Phone: 0300 123 6780
Email: developeras@lancashire.gov.uk
Your ref: 3/2025/0739
Our ref: 3/2025/0739/HDC/KW
Date: 28 October 2025

Location: Lower Abbott House Abbott Brow Mellor BB2 7HU
Proposal: Proposed replacement dwelling including amendment to facing material from previous approval 3/2022/0449.
Grid Ref: 364795 431645

project: lower abbott house 25.27
drawing number: PL.10

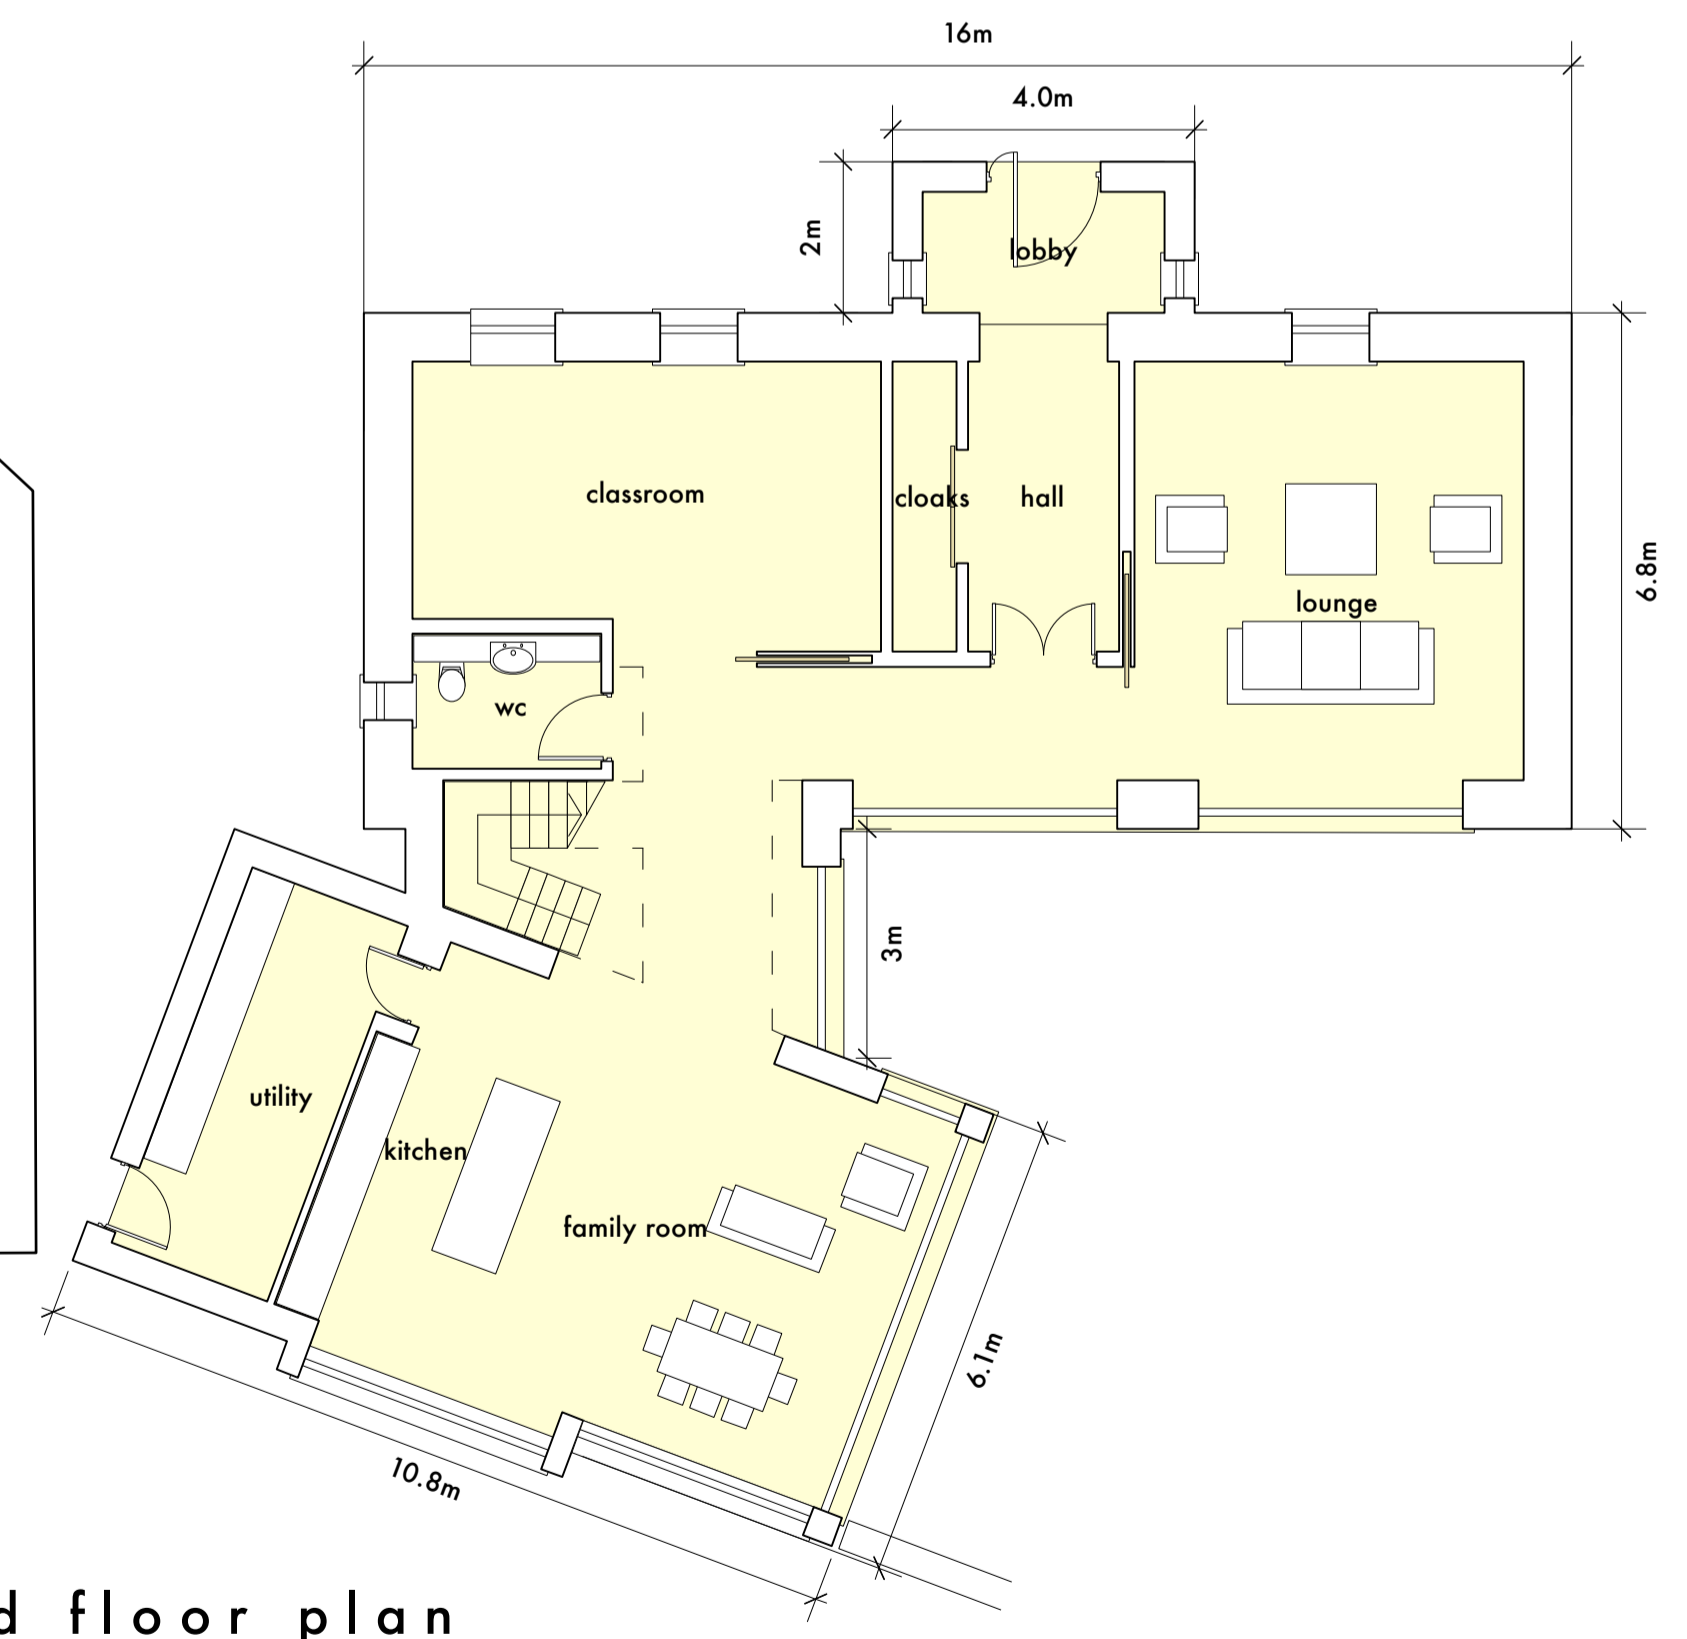
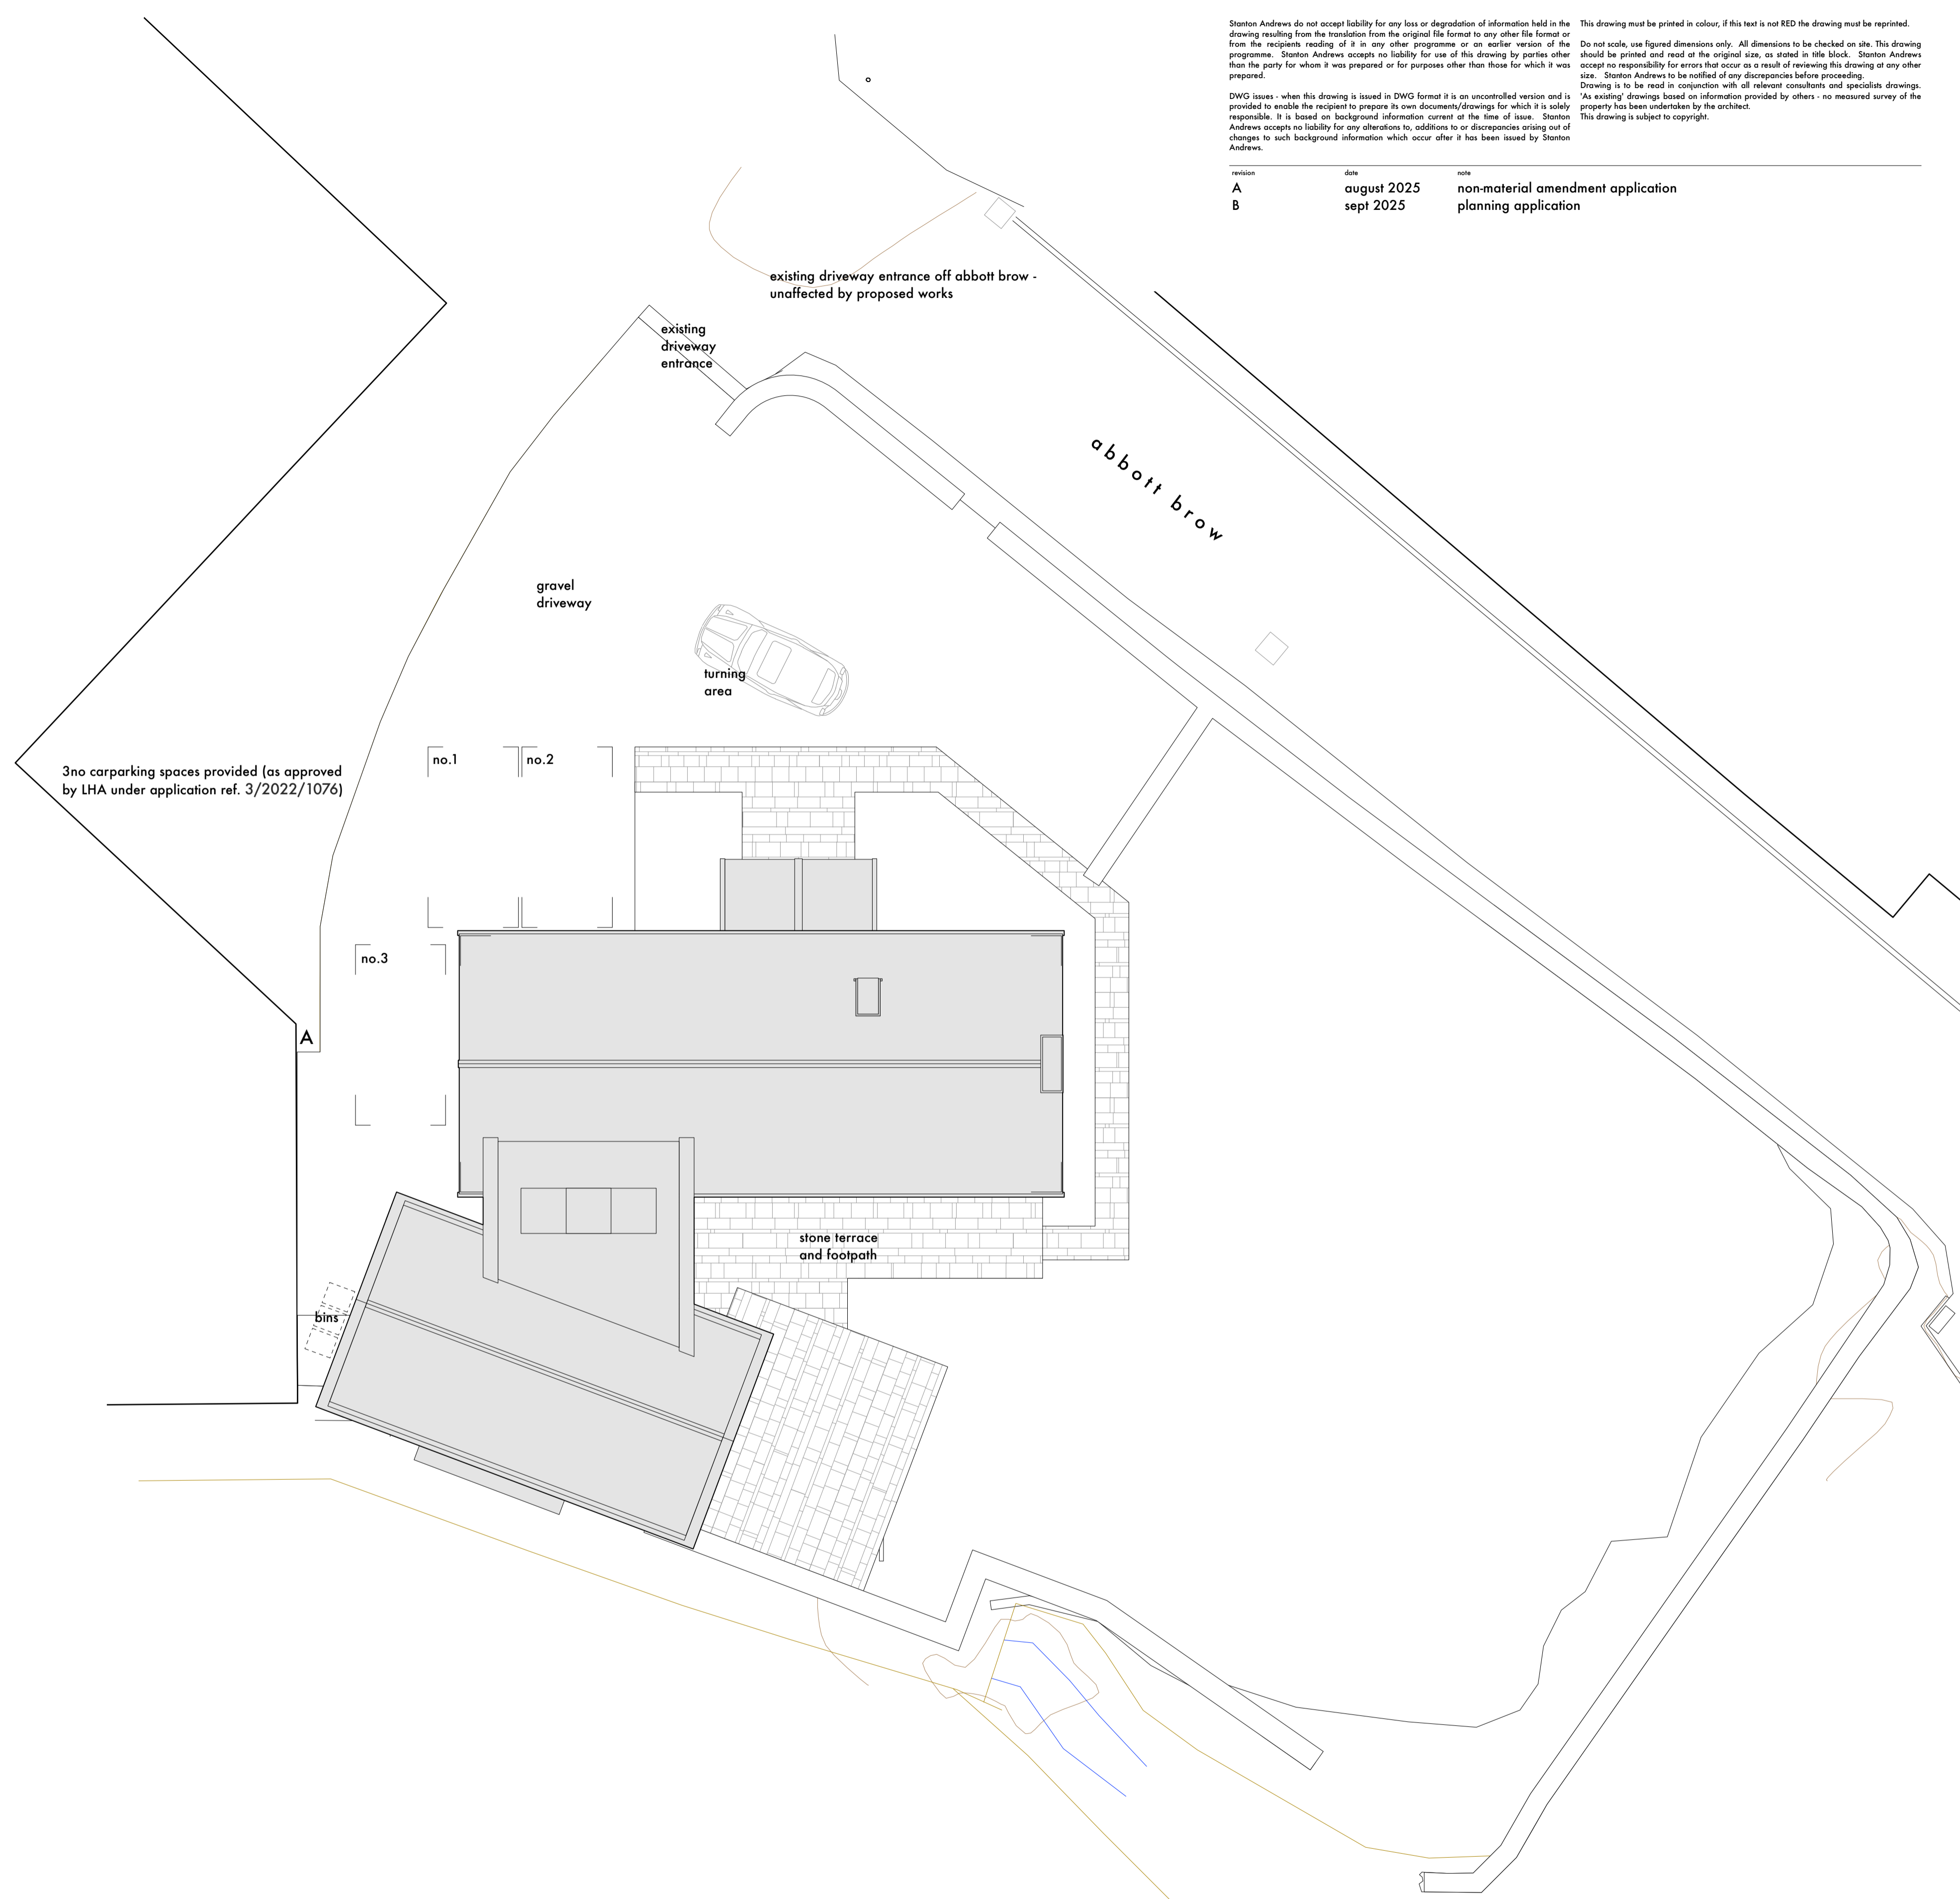
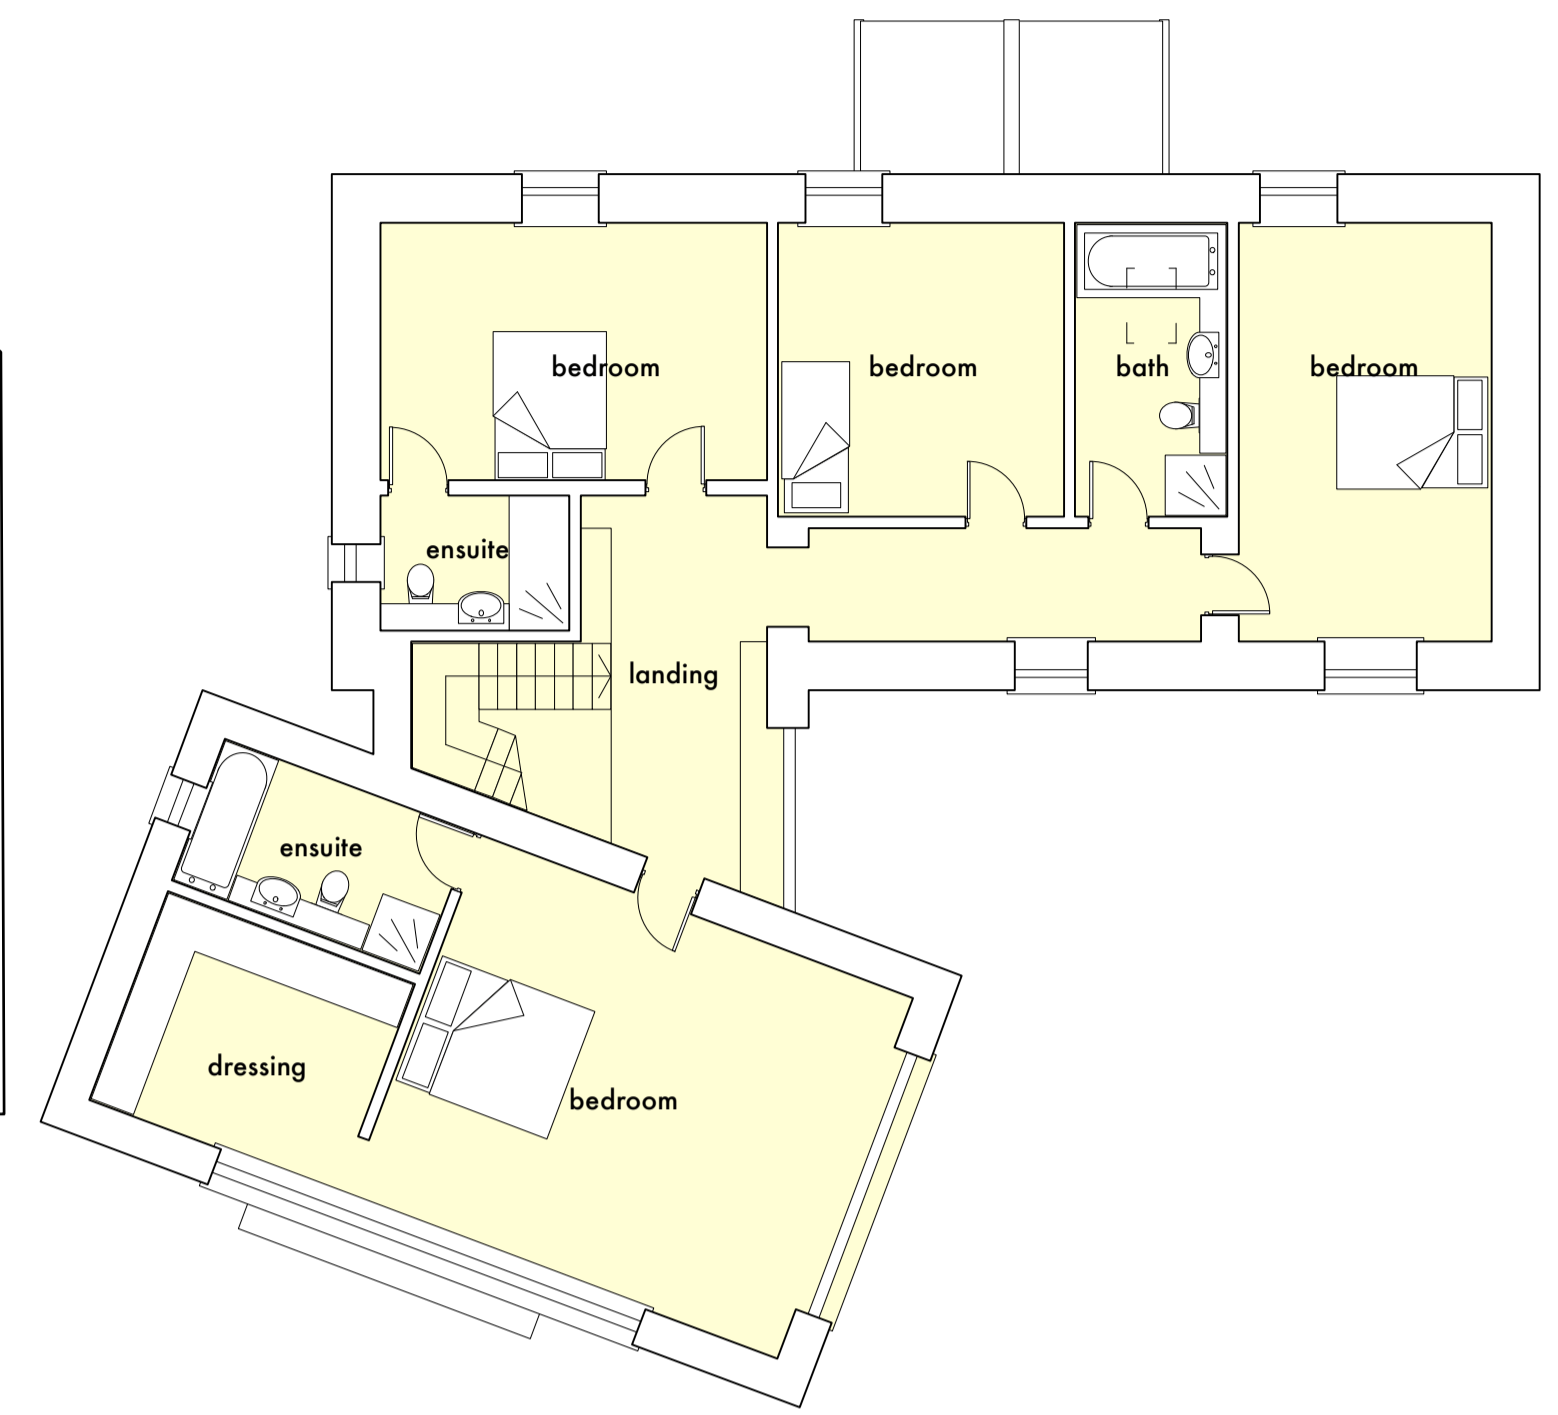
The site plan PL.10, Rev B shows that the driveway will be surfaced in gravel; however, the LHA will condition that the first 5m of the access from the adopted highway be properly consolidated and surfaced in bound porous materials (not loose stone, gravel or grasscrete) to prevent debris from being transferred onto the highway, maintained at public expense.

The LHA have reviewed drawing number PL.10 Rev B titled Proposed Site Plan and Floor Plans and understands that the site will provide 3 car parking spaces for the 4-bed dwelling. The parking provisions are also in line with the previously approved application 3/2025/0622. This complies with the Joint Lancashire Structure Plan and therefore the LHA have no objection to the proposal.

1. The development hereby permitted shall not be occupied until such time as the parking and turning facilities have been implemented in accordance with drawing number PL.10 Rev B. Thereafter the onsite parking provision shall be so maintained in perpetuity.

2. Before the access is used for vehicular purposes, that part of the access extending from the highway boundary for a minimum distance of 5m into the site shall be appropriately paved in tarmacadam, concrete, block pavements, or other hard material to be approved by the Local Planning Authority.
